Preliminary Acceptance (PA) Punchlist
EPC - DPW - Stormwater Section

Project Name:	Hills at Lorson Ranch
EDARP Filing Number(s):	SF2110, PUDSP203, CDR207, PUDSP216
ESQCP Number:	ESQ2033
Attendees:	DPW SW: Natasha Grimaldo, Ben Jones DPW Planning: N/A Developer: Jeff Mark/Lorson LLC
Date of Walk-Thru:	3/6/2023
Walk-Thru Number:	1st

**EXISTING POND C1 EXPANSION
POND GRADING AND
TRICKLE CHANNEL**

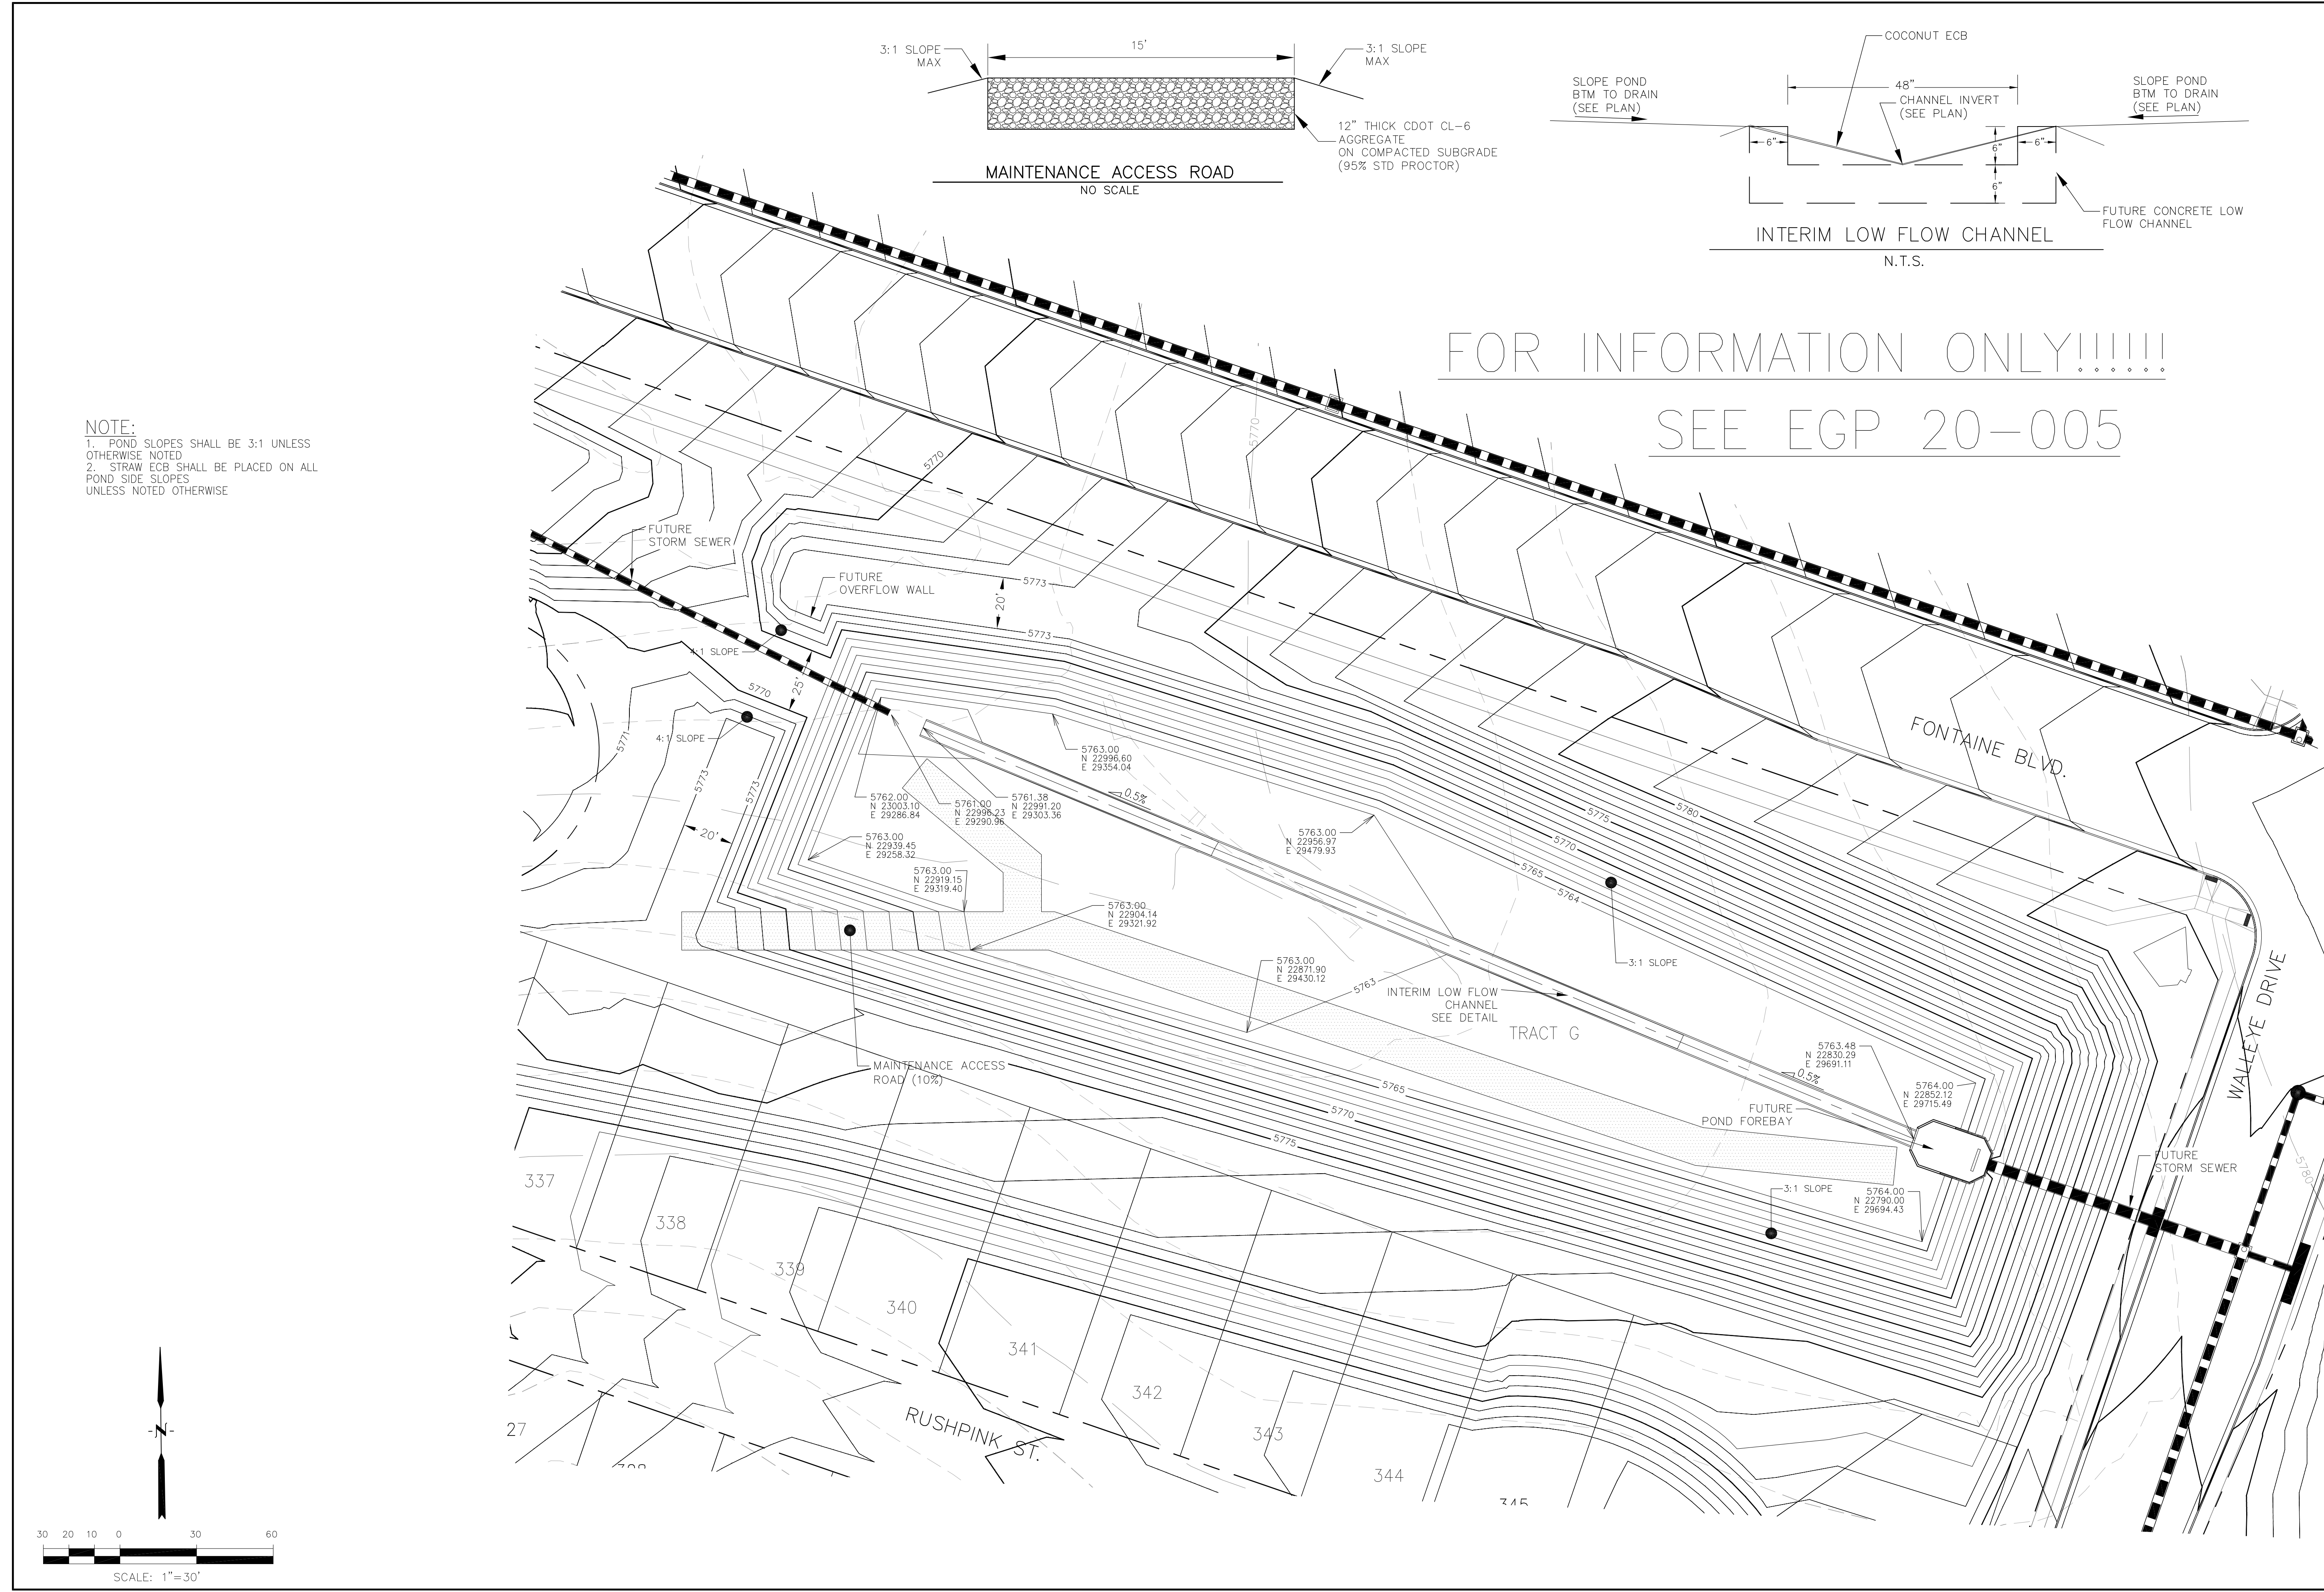
Pond C1 (CDR207):

- Orifice plate was not properly installed. Invert of the bottom most hole should be at the same elevation as the invert of the outlet pipe.
- Remove sediment and debris from forebay 1 (SF 2110).
- Repair crack in concrete where forebay 1 meets the trickle channel.
- Repair cracking at south forebay pipe entrance.
- Remove debris and sediment from outfall structure micropool.
- Remove excess sediment and old straw wattles from trickle channel.
- Raise pond bottom to top of trickle channel curb with a 3% slope towards trickle channel for positive drainage.
- Remove sediment to match the top of trickle channel curb with a 3% slope towards trickle channel for positive drainage.
- Remove old/damaged straw wattles from pond bottom.
